MEMORANDUM

TO: Jean Fraser, Planner
FROM: David Senus, P.E.
DATE: May 1, 2015
RE: 1342 Congress Street Neighborhood Center, Preliminary Level III Site Plan Application

- Preliminary Level III Site Plan Application and attachments, dated April 3, 2015, prepared by Tighe & Bond, on behalf of the Jewish Community Alliance of Southern Maine.
- Engineering Plans, Sheets C-1 through C-9, dated April 3, 2015, prepared by Tighe & Bond, on behalf of the Jewish Community Alliance of Southern Maine.

C-9

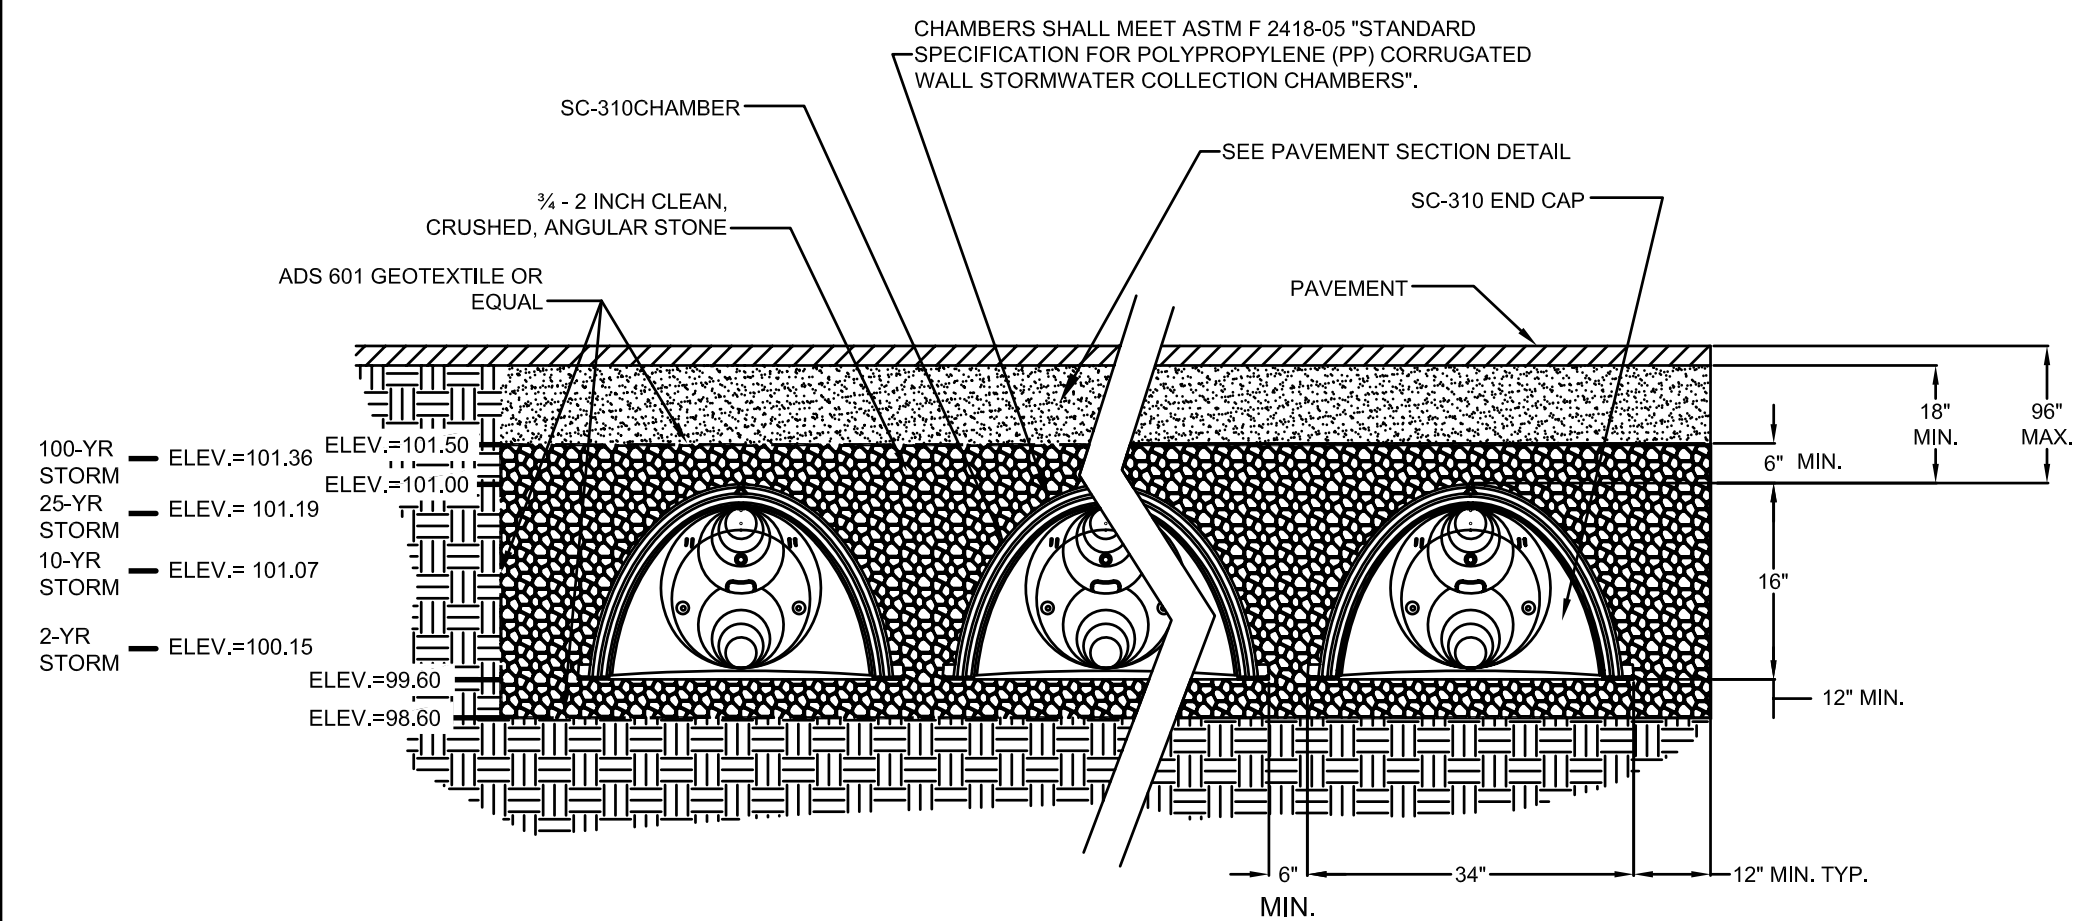
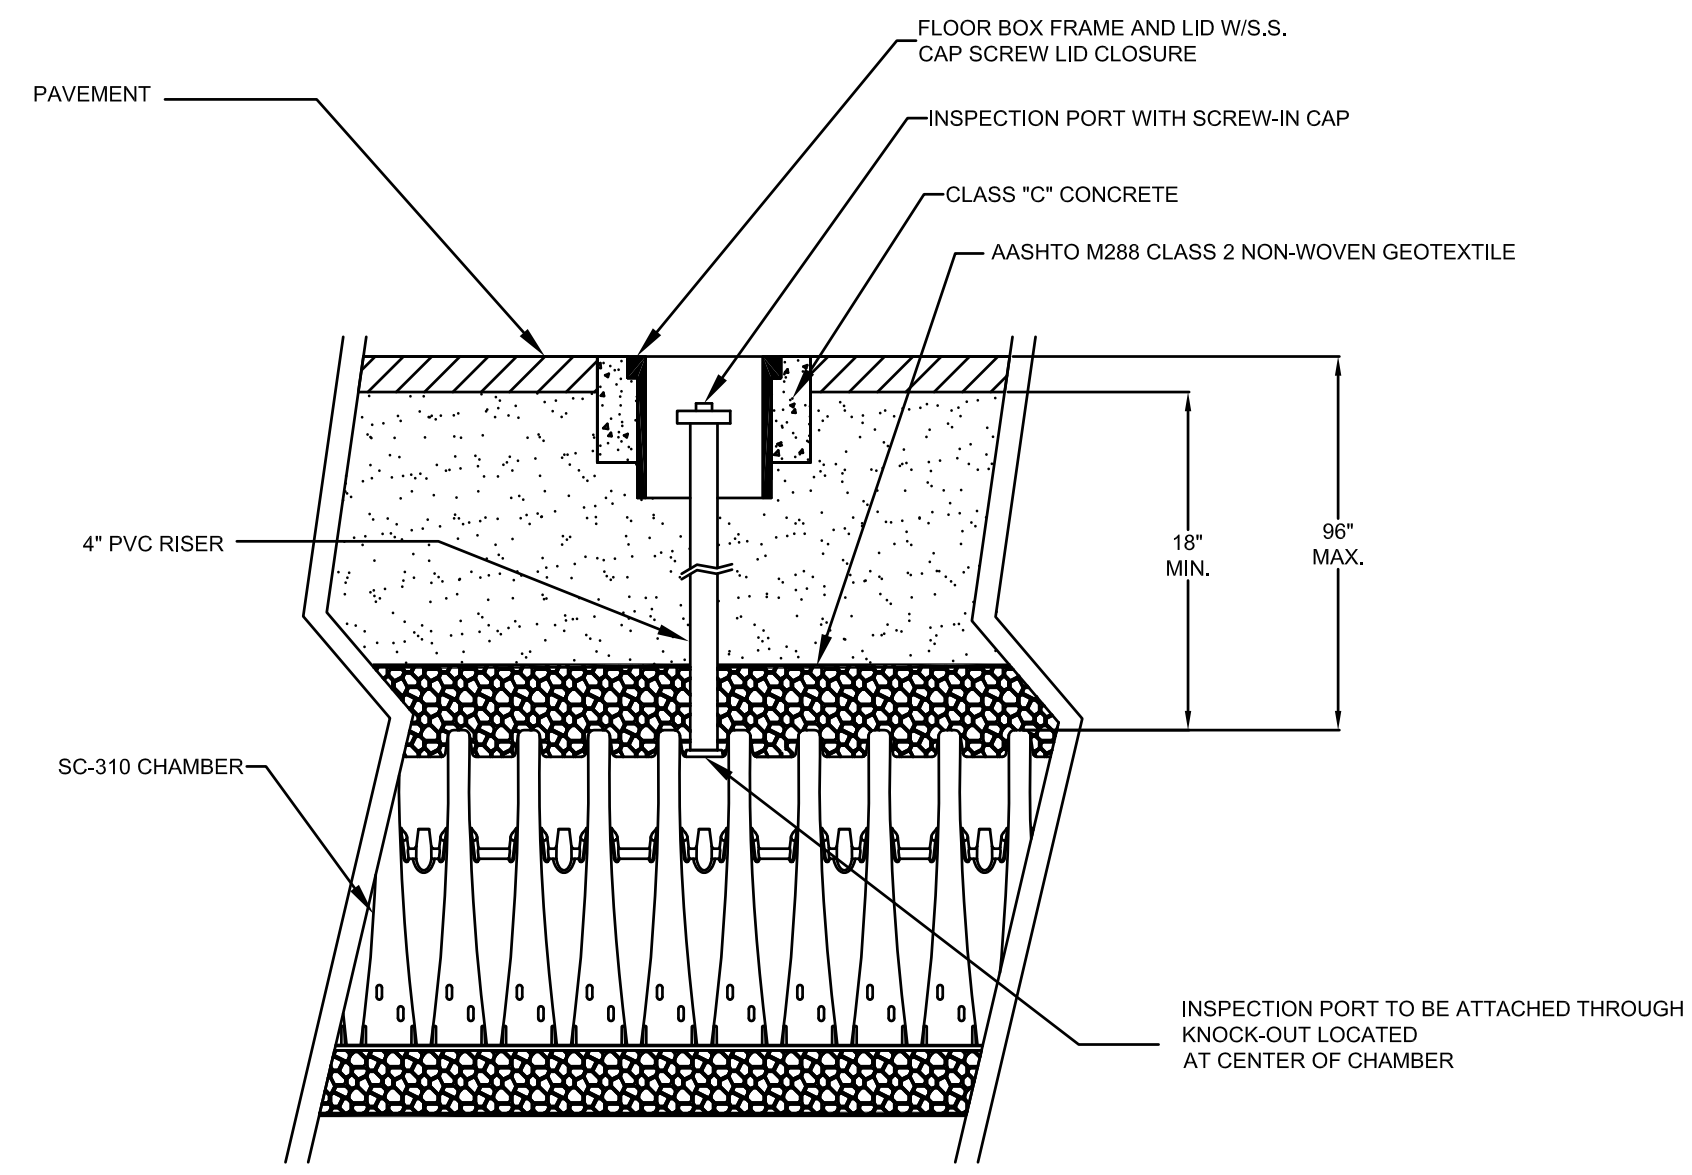
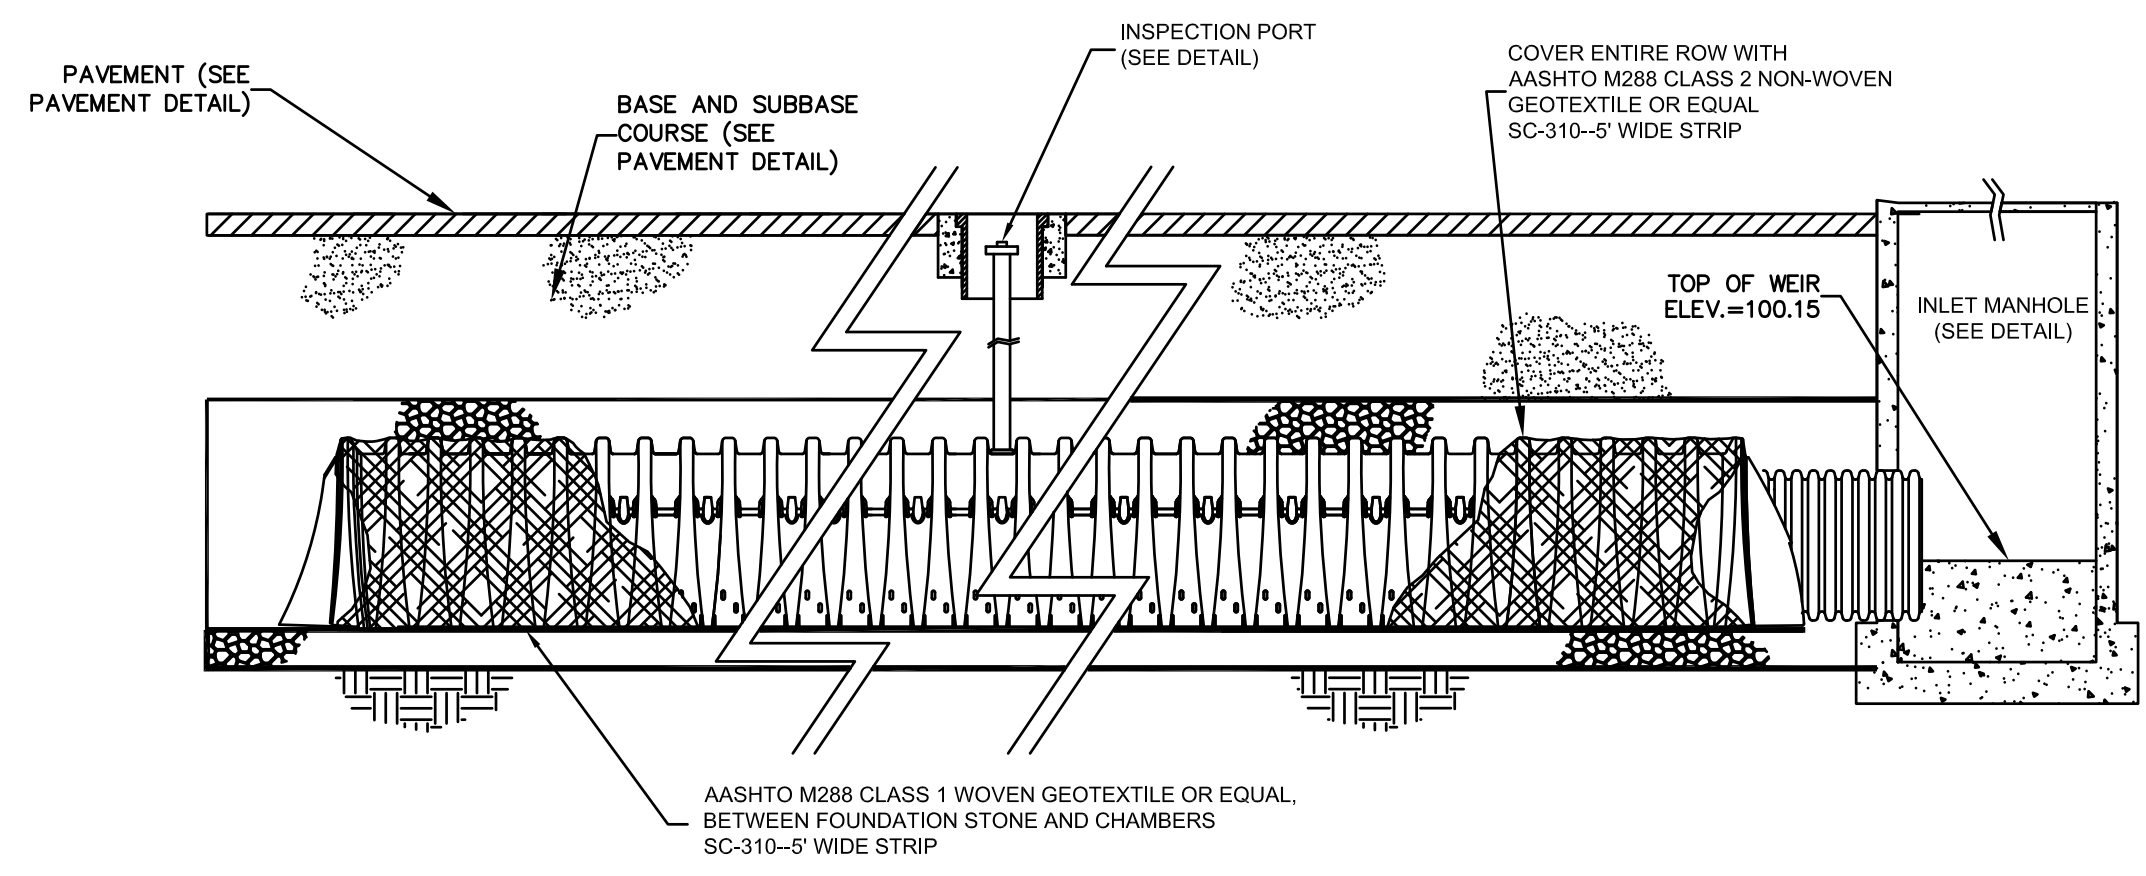
- ii) Future submittals should include details for the outlet control structures associated with the soil filter and the StormTech Chamber system, including orifices and weirs.

- iii) Future submittals should identify key elevations for the StormTech Chamber detail matching to the elevations utilized in the HydroCAD model.
 - iv) The Pre-Development Watershed Plan (WS-1) indicates that runoff from the existing building roof is part of catchments WS-1 and WS-2; however, runoff from some of these roof areas is collected in downspouts that enter into the ground and which do not appear to flow to PA-1 and PA-2. The Applicant should determine the discharge location for the building's roof downspouts and re-evaluate the catchment areas and stormwater model based on their findings.
